DECISION DELEGATED TO HEAD OF PLANNING

Application No: H04-0918-22 **Applicant:** D S M Construction Services Ltd

Proposal: Proposed two storey and single storey rear extensions and removal of existing garages.

Location: 13 Church Street Donington Spalding

Title  
Proposed Plans

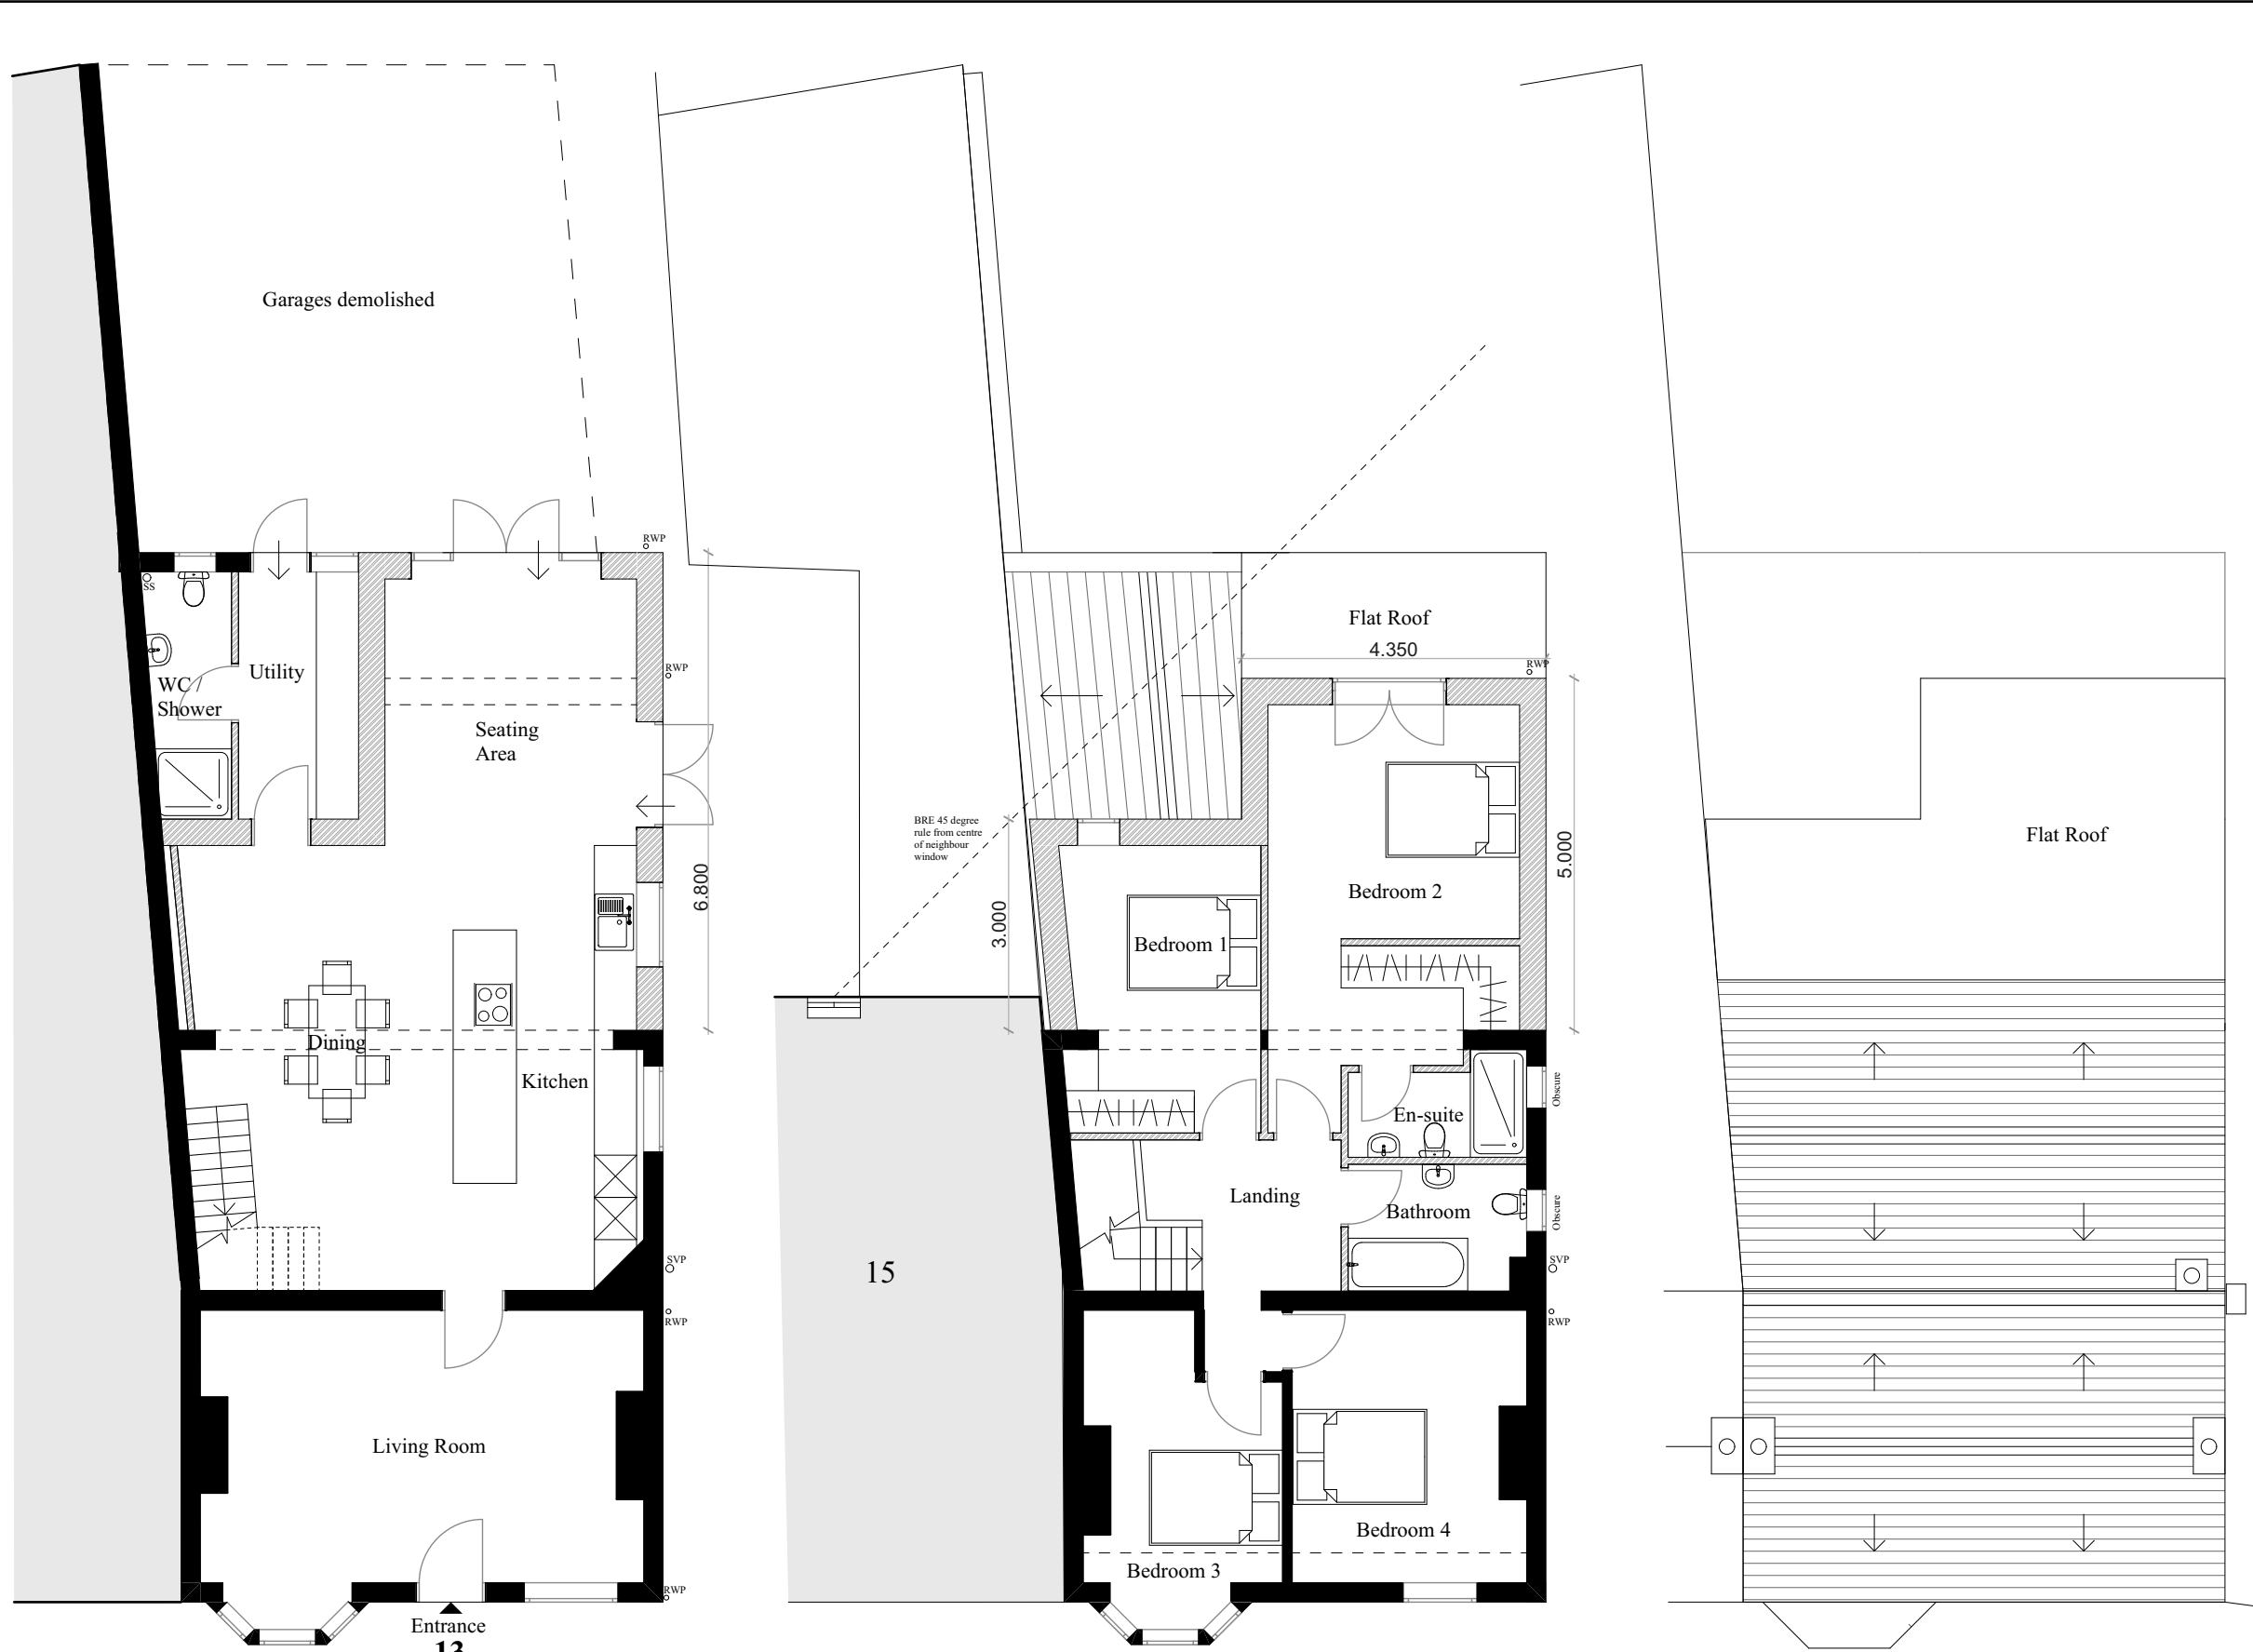
The proposed development will include the demolition of the existing garage at the rear, which is of no architectural or historic merit. The proposed ground floor extension will protrude from the rear elevation of the existing kitchen, by approx. 6.8m and carry the same width as the original dwelling. To the first floor, the proposed extension will also protrude from the rear elevation, forming an L-shape include and minimum protrusion of approx. 3m and a maximum of approx. 5m.

Internally, the purpose of the development is to gain further internal floor space for enlarging and creating new rooms inside the house. To the ground floor this includes enlarging the existing kitchen, and creating an open plan kitchen, dining and seating area. The extension will also include a utility room and a downstairs w/c and shower room.

To the first floor, the extension will include the addition of a family bathroom, a new master bedroom with an ensuite and also enlarging the first bedroom. The first floor will also have an enlarged landing, creating a more open space to the first floor. The number of bedrooms will stay the same. Overall, the proposals will ensure good living conditions for the house occupiers and is in keeping with the residential use of the property.

The centre of the rear first floor bedroom window to no. 15 is at a greater than 45 degree angle from the shortest part of the rear extension. It is therefore considered that there will not be a material amenity impact in that direction.

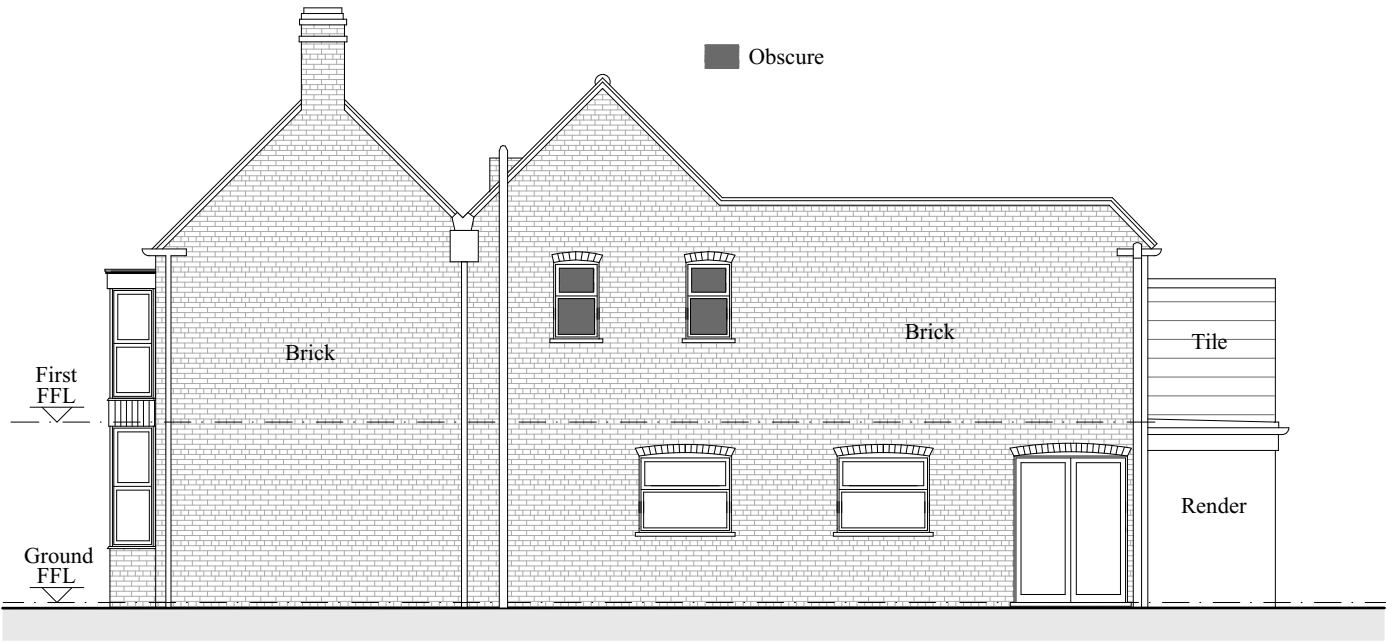
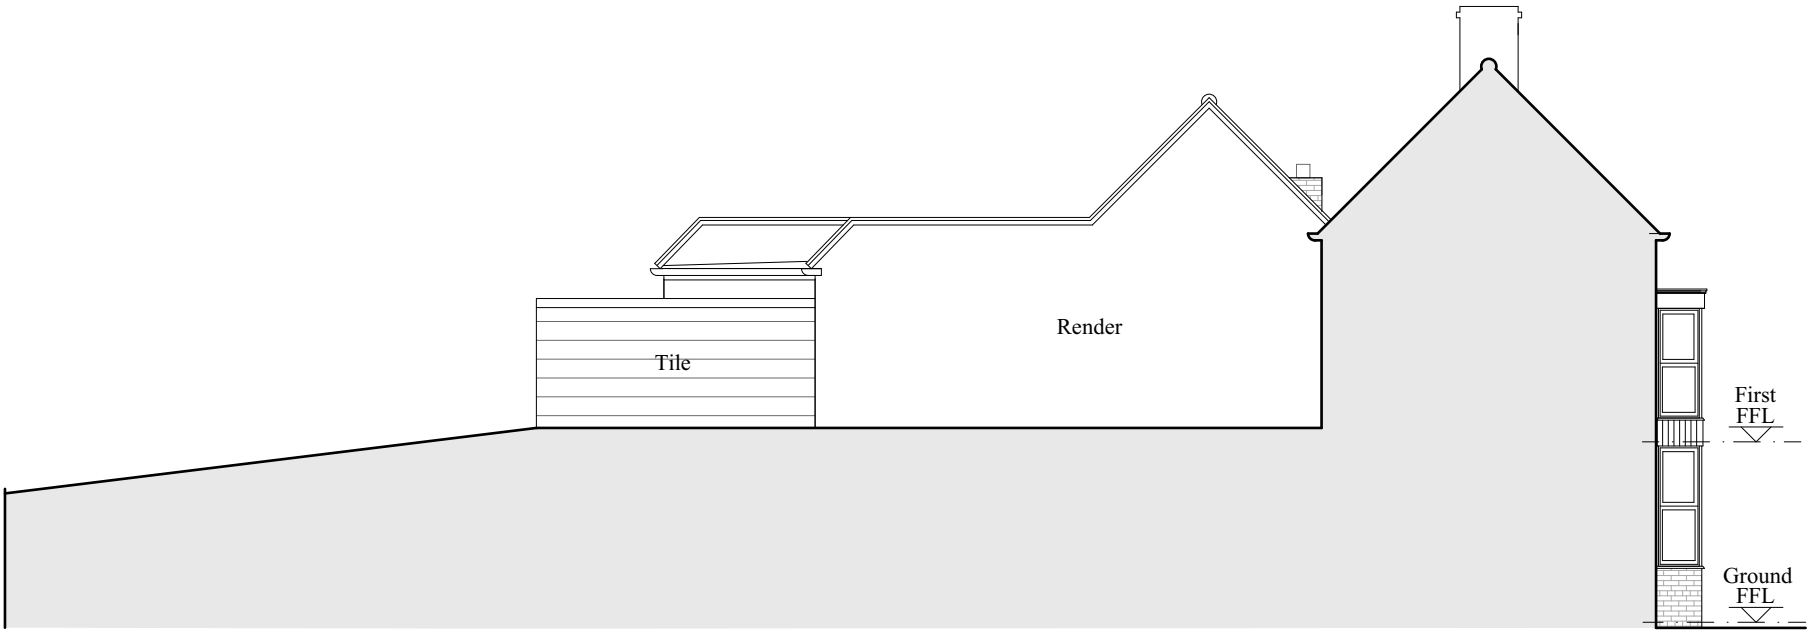
The external materials include facing brickwork to the southern elevation, with off white render to the north side and rear elevation. Roof tiles, white UPVC/aluminium in fenestration and rainwater goods will match those existing in the property. As much as UPVC windows are not favourable within a Conservation Area, there are already UPVC windows on the property currently and is therefore justifiable.

The roof will be formed to include a gable roof to the first floor and also partial to the ground floor extension. There will also be a partial flat roof to the first floor at the rear (reflecting the existing arrangement) and to the ground floor rear extension. As much as flat roof extensions are not considered favourable, the first floor already has a flat roof and it would be set back further by virtue of the side gable part. The side south elevation is a large elevation, but the proposed two windows on that elevation provide some relief.

Two obscure glazed windows are indicated on the southern elevation at first floor, plus windows and doors to the kitchen and seating area at ground floor. No. 13 and the dwelling to the south are separated by an access to the land to the rear. As such, and given the location of the dwelling to the north of no. 11, it is not considered there would be a material overlooking, overshadowing or overbearing impact. The windows to the rear will overlook an industrial unit therefore there will be no impact on neighbouring amenity in that respect.
